## DOCUMENT 4 –

### Response to ExA’s Written Questions

| ExQ1  | Question:   | Canal & River Trust Response   |

Appendix 2 – Bridge Design / layout and Gravelly Way access

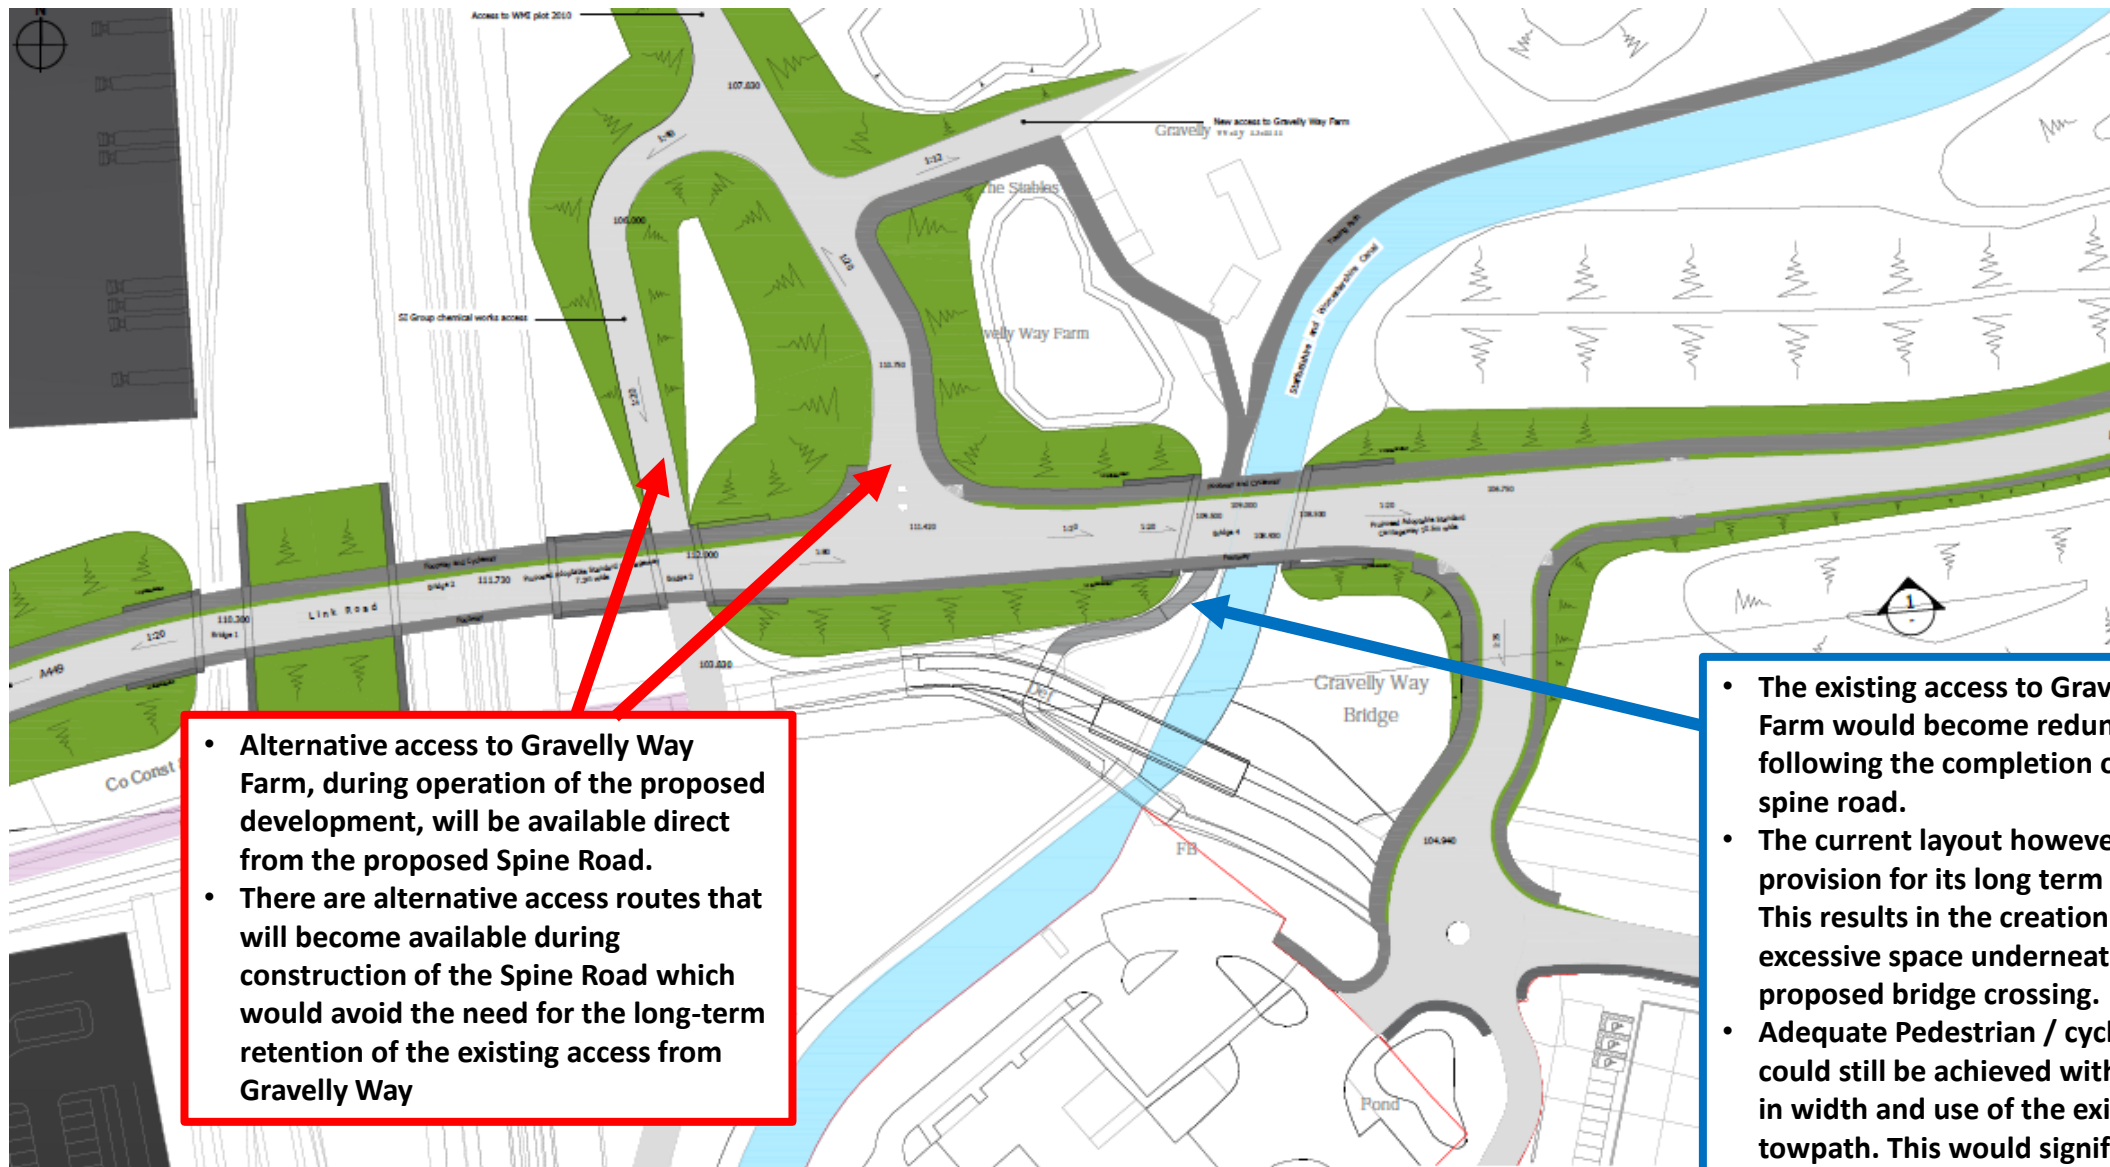
| 1.15.4 | <p>CRT [RR 1155] has raised concerns about the proposed retention of the access track from Gravelly Way which it says would result in the proposed new Link Road Bridge over the canal requiring a materially wider span than would otherwise be needed. CRT is concerned about large spaces being created beneath bridges over the canal as these can attract anti-social behaviour.</p>  | <p>In principle the general positioning of the bridge and its proposed height above the canal is accepted by the Trust.</p> <p>The specific layout and design for the proposed road bridge crossing and surrounding pedestrian/cycle linkages though have altered significantly from that presented as part of the</p>   |

|        | <p>(i) Can the Applicant clarify its proposals in relation to this issue and advise what if any agreement is in place between the parties?</p> <p>(ii) The ExA wishes to receive a signed SoCG between the Applicant and the CRT which provides a position statement on discussions over the CRT's other concerns about the design of the Link Road bridge as set out in its RR and clearly identifies what is and what is not agreed in relation to this key element of the Proposed Development.</p> | <p>pre-application consultations. The bridge layout and design, as currently shown within submitted documents refs: 2.17, 2.18A &amp; 2.18D, is not acceptable to the Trust for the following reasons:</p> <ul style="list-style-type: none"> <li>• Bridge Span</li> <li>• Retention of the access track and pedestrian / cycle connections to existing bridges and the towpath</li> <li>• Offside abutment</li> <li>• Design</li> <li>• Parapets</li> </ul> <p>The Trust acknowledge that the bridge design submitted is only illustrative at this stage though it is not clear if the layout of the bridge and adjacent land is also indicative only. If these aspects are also illustrative only at this stage it is considered that the matters above could be dealt with at a later stage in consultation with the Applicant.</p> <p>The detailed design and construction of the bridge crossing will need to be agreed by the Trust and all works will follow the Canal &amp; River Trust's "<i>Code of practice for Works affecting the Canal &amp; River Trust</i>"</p> <p>The Trust received a first draft of a '<i>Statement of Common Ground</i>' from FAL on the 11<sup>th</sup> March 2019 and have been reviewing this document as a matter of urgency. It has not been possible, in this short period of time, to agree a final version of this document. The Trust have now provided FAL with our comments on this first draft. The concerns of the Trust are however clearly set out above and in our Written Representation dated 5<sup>th</sup> April 2019.</p> |

# Appendix 5

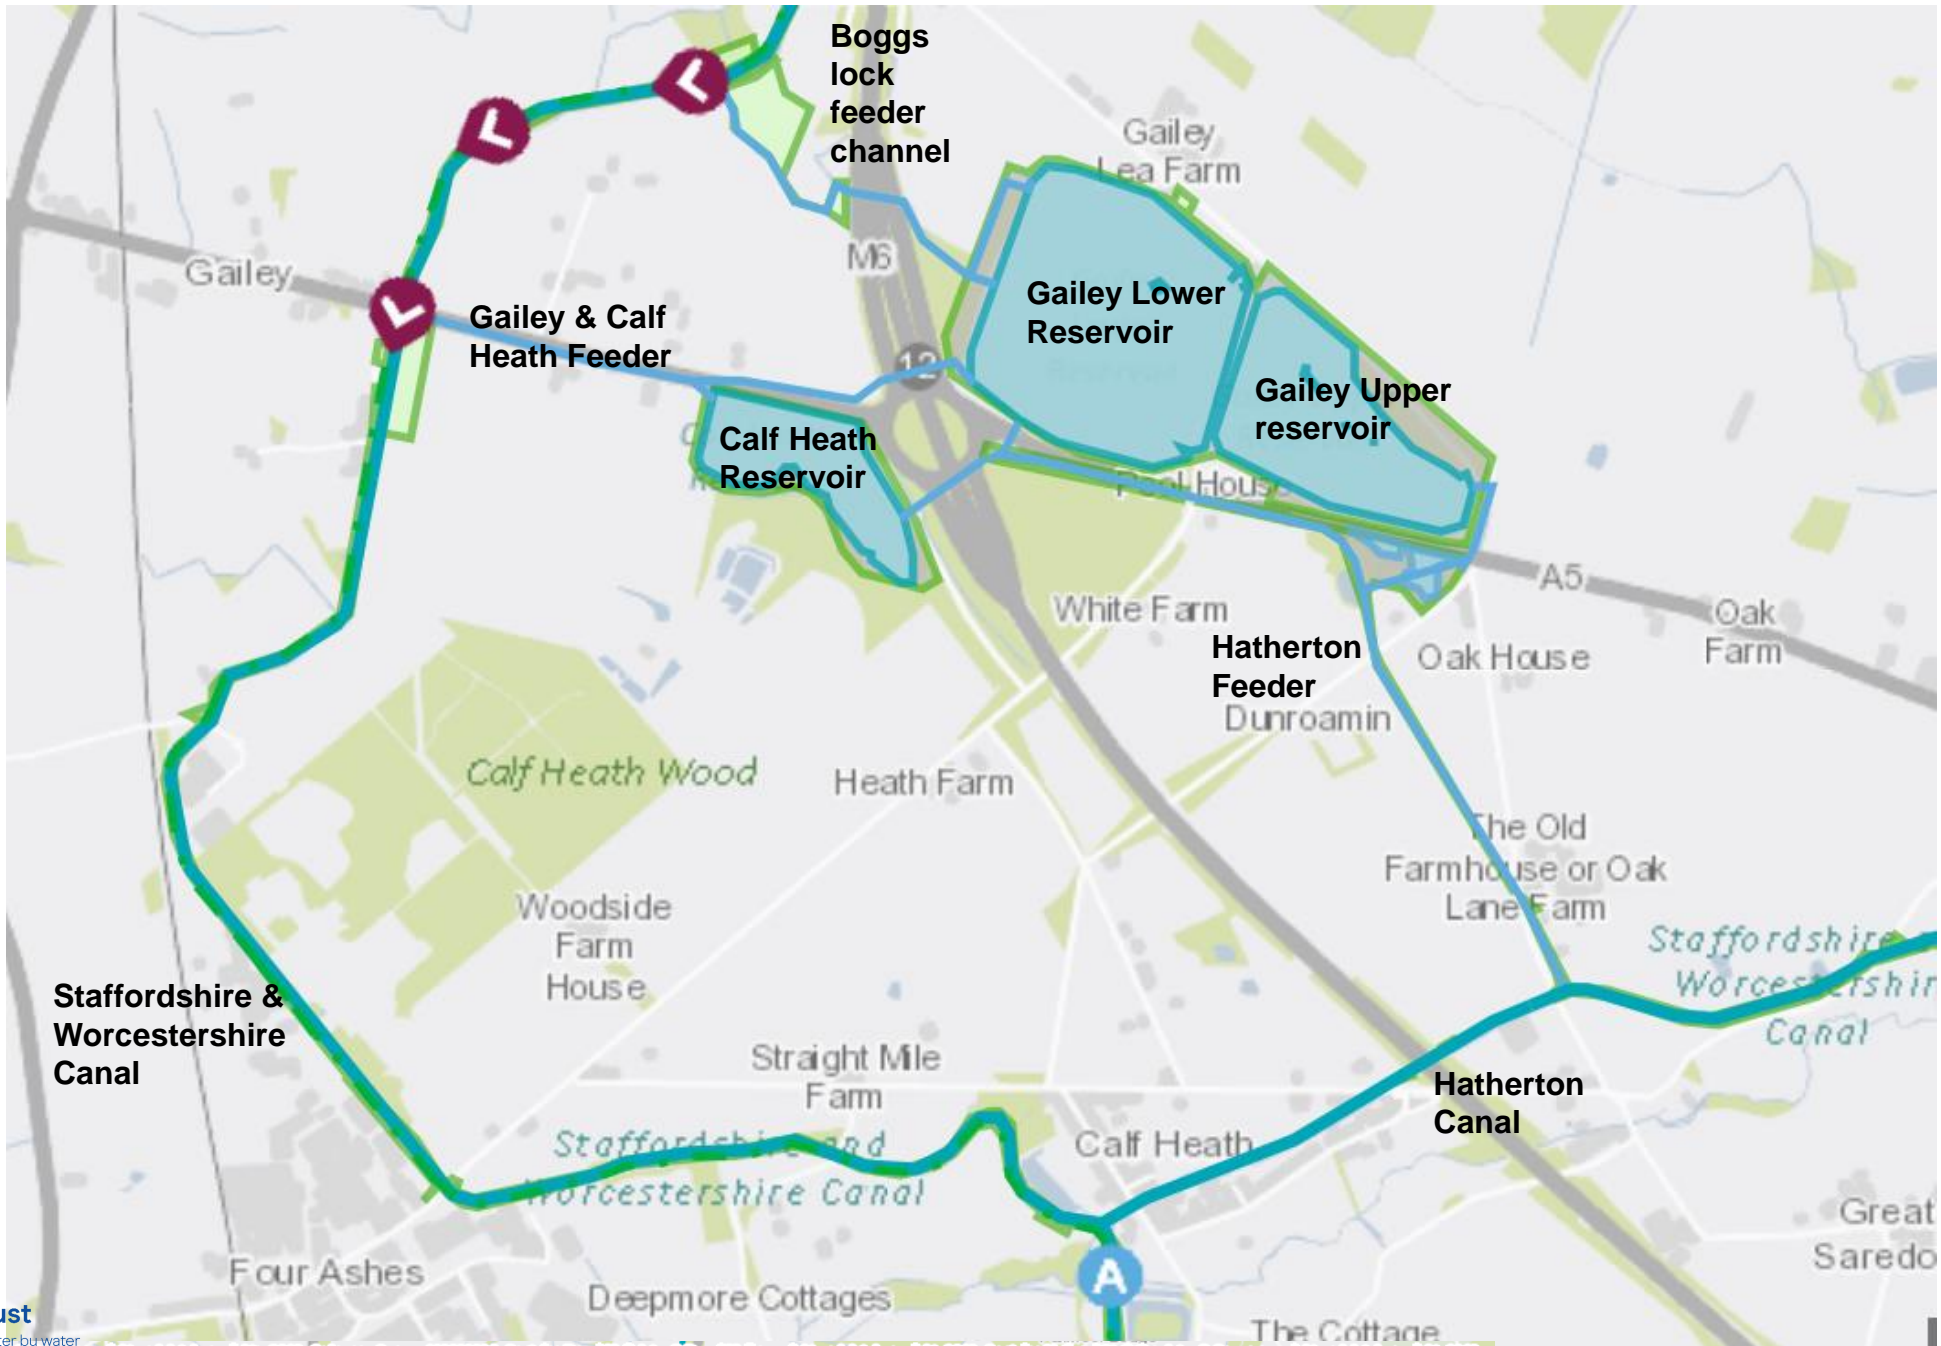
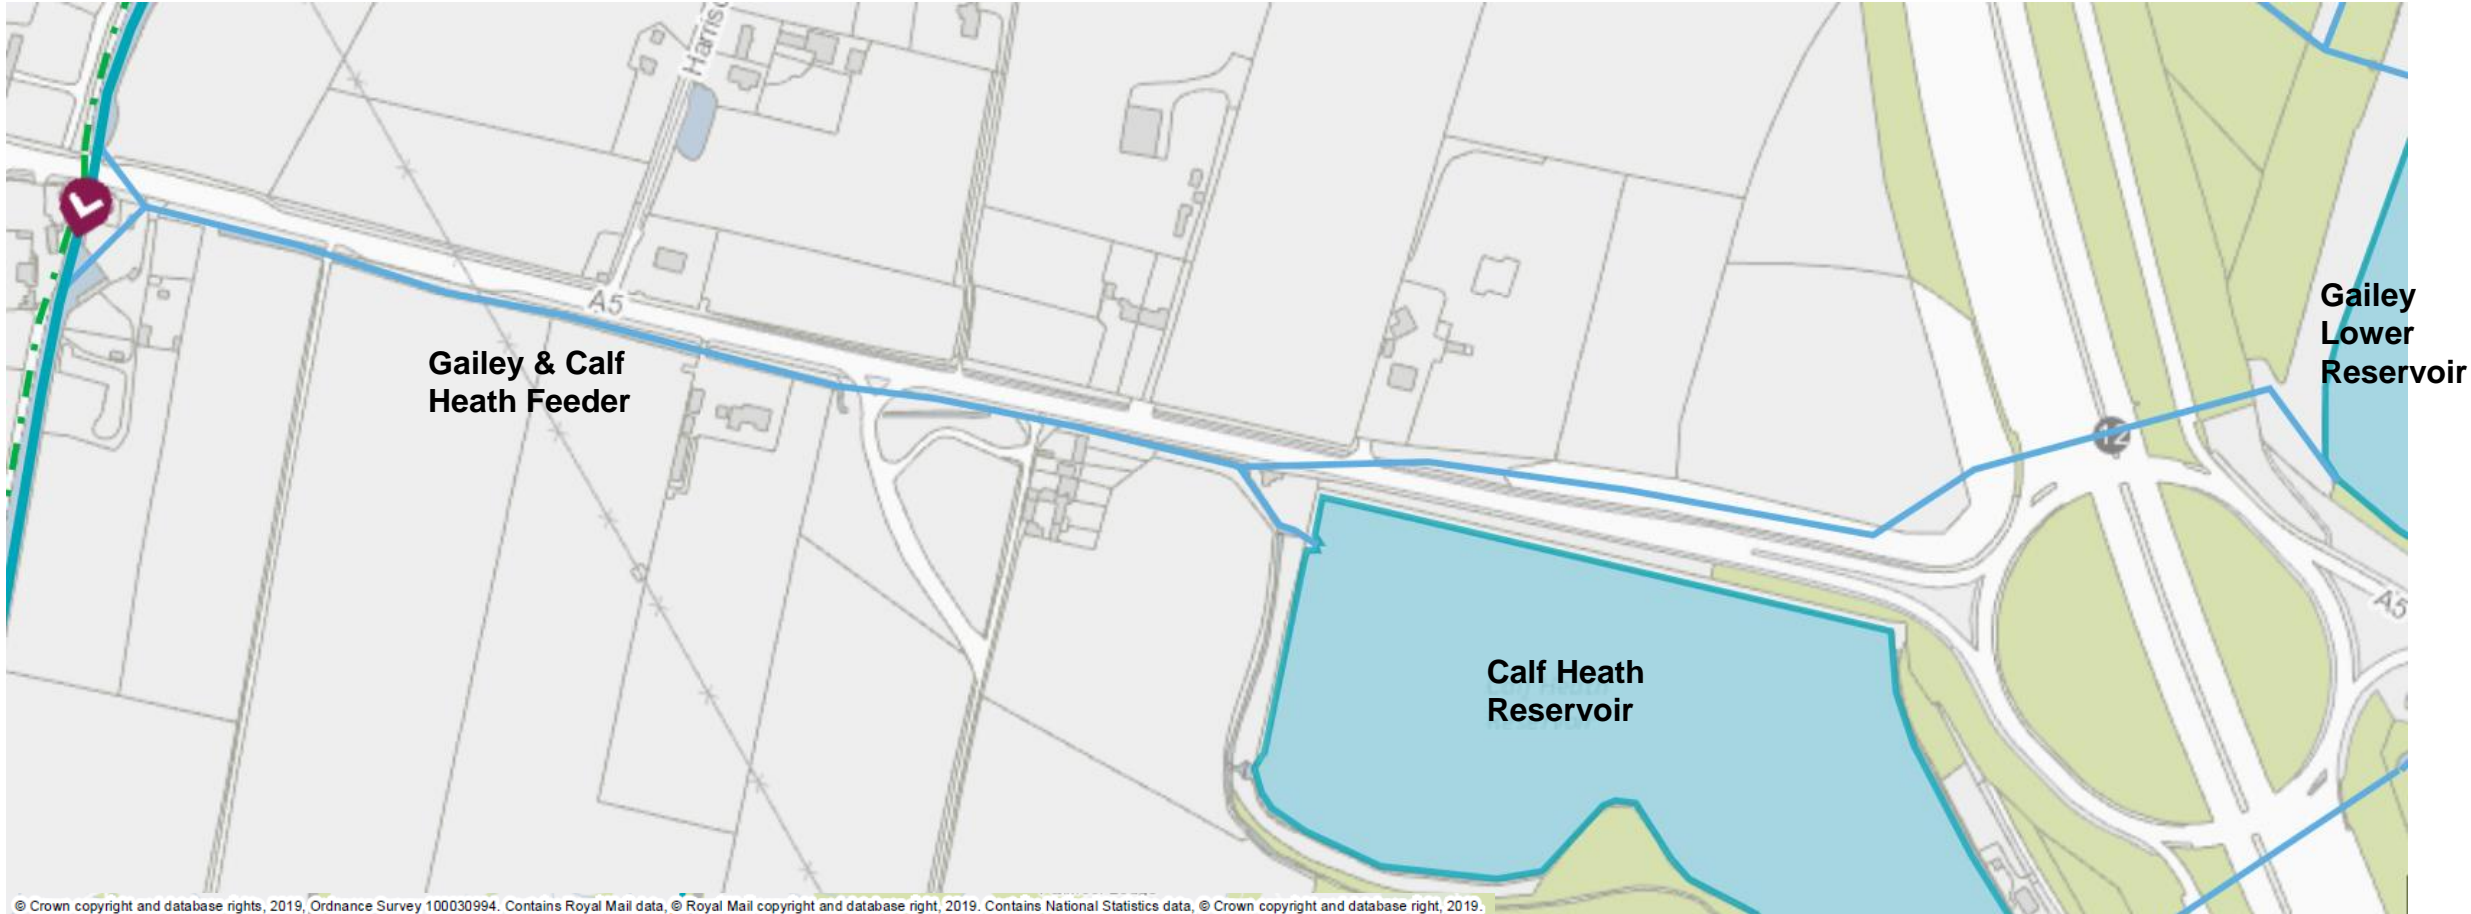
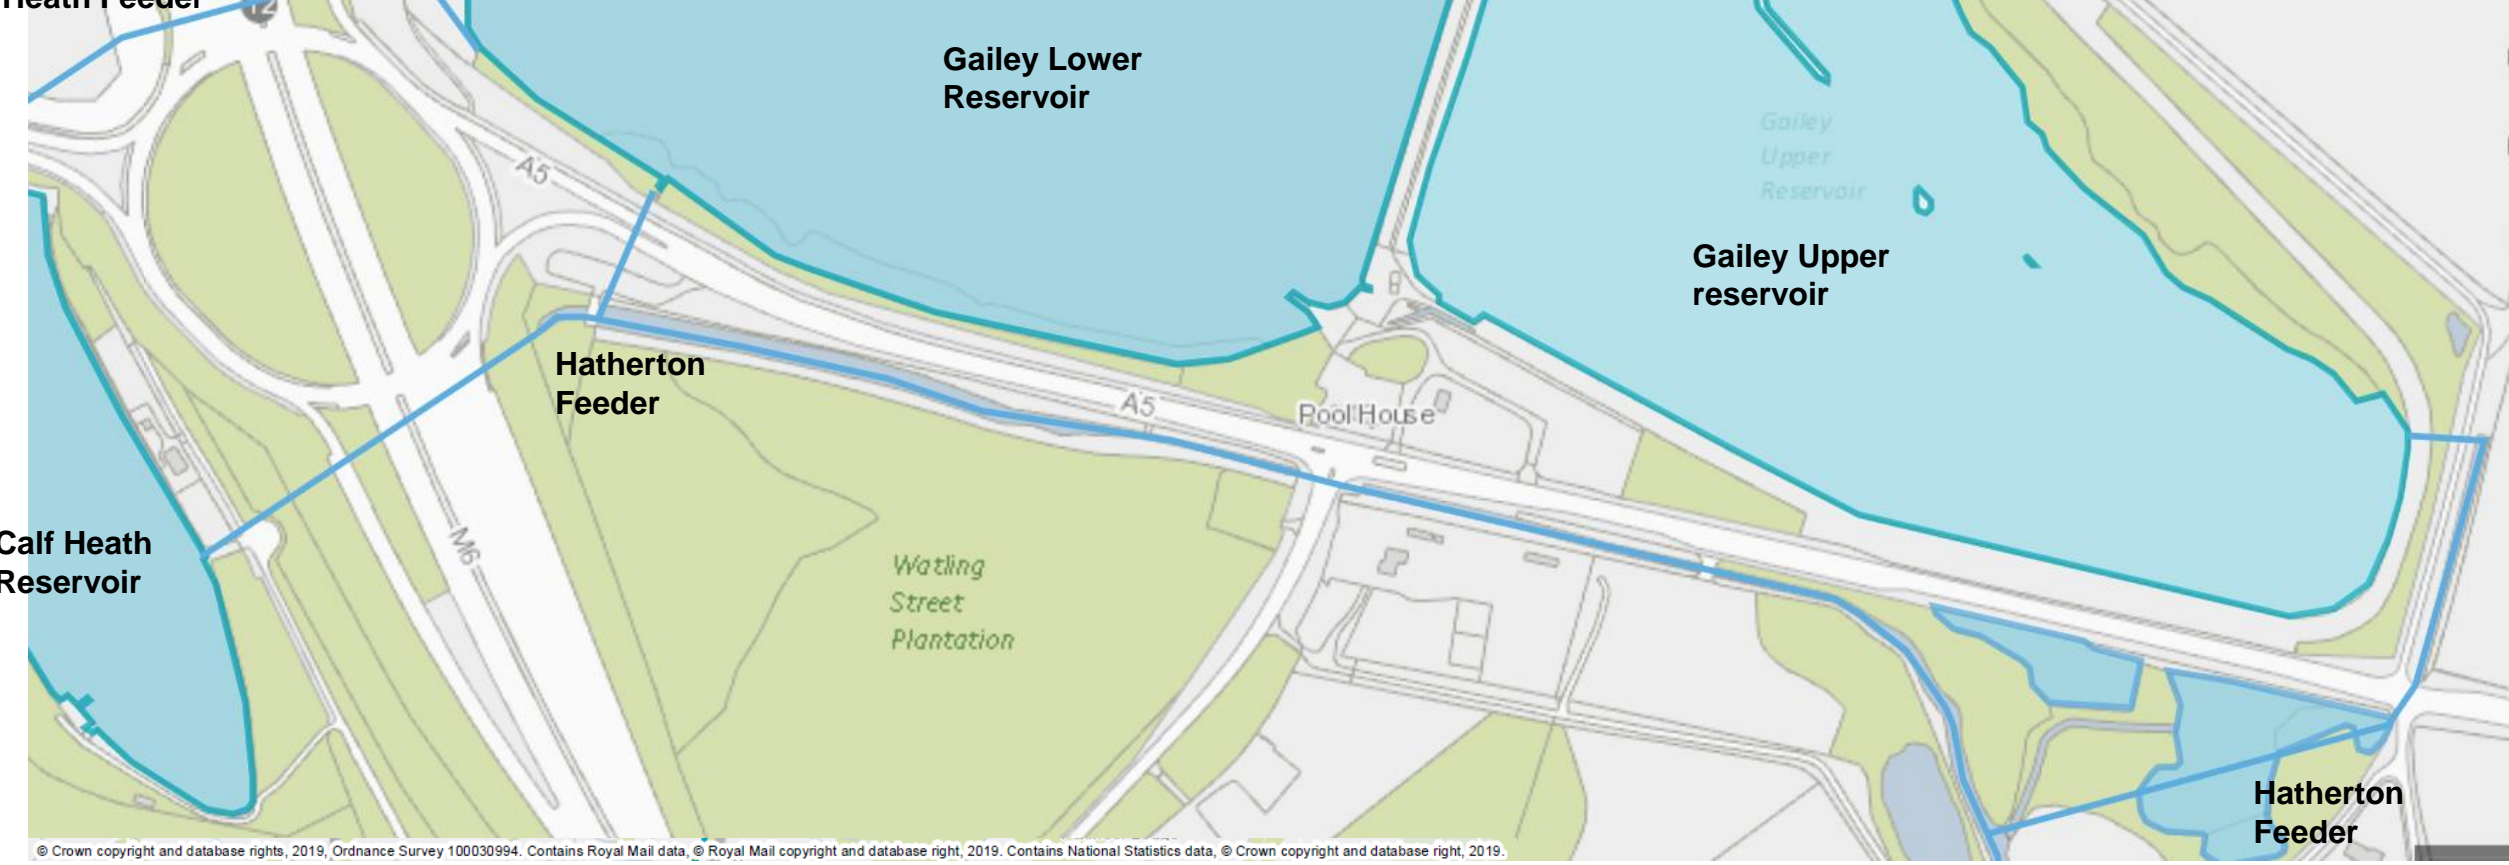
| ExQ1  | Question:   | Canal & River Trust Response   |
|-------|---|--|
| 1.0.2 | <p>ES Appendix 12.7 [APP-105] describes Calf Heath Reservoir as “one of two such features to either side of the junction with the M6 motorway serving as balancing ponds from the original construction of the road.” In many other places in the submission documents both Calf Heath and Gailey Reservoirs are described as feeder reservoirs for the Staffordshire &amp; Worcestershire Canal (S&amp;WC). Please confirm the main use of these reservoirs and whether this use continues to comprise their main purpose.</p> | <p>None of the reservoirs were constructed in relation to the M6. They are not and have never been used as balancing ponds in connection with the Motorway.</p> <p>Calf Heath Reservoir was constructed between 1778 and 1799 to supply the summit pound of the Staffordshire &amp; Worcestershire Canal. The reservoir has a surface area of 0.073 km<sup>2</sup> and a capacity of 165,000 m<sup>3</sup> at the normal top water level of 106.64 mOD. The reservoir can still be used to supply the canal and is also used for angling and sailing.</p> <p>Gailey Lower Reservoir and Gailey Upper Reservoir were constructed in about 1855 to supply the Staffordshire &amp; Worcestershire Canal, a function they still serve today. The Lower Reservoir is also used for sailing; the Upper Reservoir is used for angling. Gailey Lower Reservoir has a surface area as 0.251 km<sup>2</sup> and a capacity of 778,000 m<sup>3</sup> at the top water level of 105.09 mOD. Gailey Upper Reservoir has a surface area of 0.146 km<sup>2</sup> and a capacity of 356,000 m<sup>3</sup> at the top water level of 106.99 mOD.</p> <p>Maps showing the reservoirs and feeder channels can be found in Appendix 5 of the Trust’s Written Representation dated 5.4.19</p> |
